**Recommendation Report for Listed Building Consent for Alterations, Extension or Demolition of a
Listed Building**

REF NO: BN/38/18/L

LOCATION: Parsonage Farm House
Lake Lane
Barnham
PO22 0JD

PROPOSAL: Listed building consent for an annexe extension ancillary to the main dwelling.

Proposed

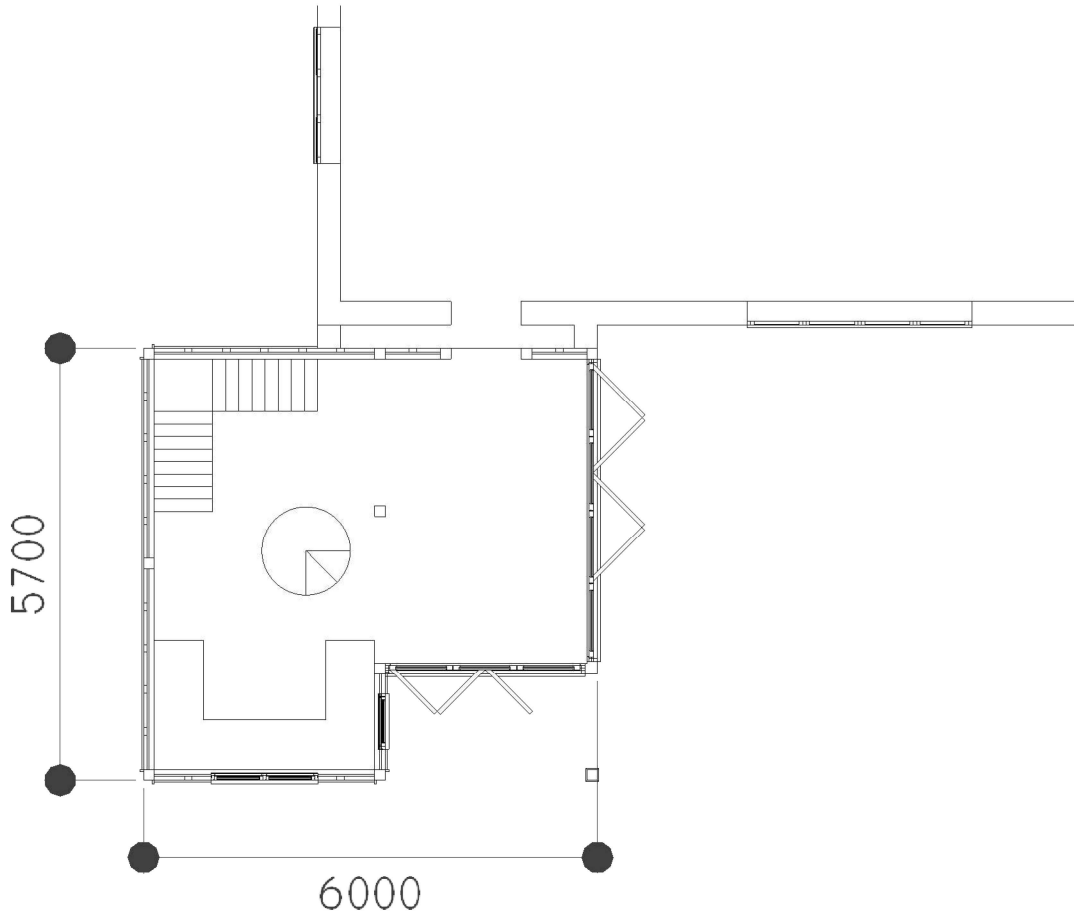
Amendments appear to be minor.

Previous comments haven't been taken into account.

Due to the very minor level of change, my previous comments still apply.

Proposal appears as an afterthought. As if been tacked onto the corner of existing building.

Extension is taller than part of listed building it adjoins.

It is considered that the proposal would appear as an incongruous addition that does not integrate satisfactorily with the host building, in this case the the Grade II Listed building known as Parsonage Farm House.

- 1 The manner and form of the extension would not integrate satisfactorily with the host building and as such, would adversely affect the character and appearance of the Grade II Listed Building and conflict with the National Planning Policy Framework and Policies HER SP1, HER DM1 of the emerging Local Plan and ES7 of the Barnham Neighbourhood Plan.
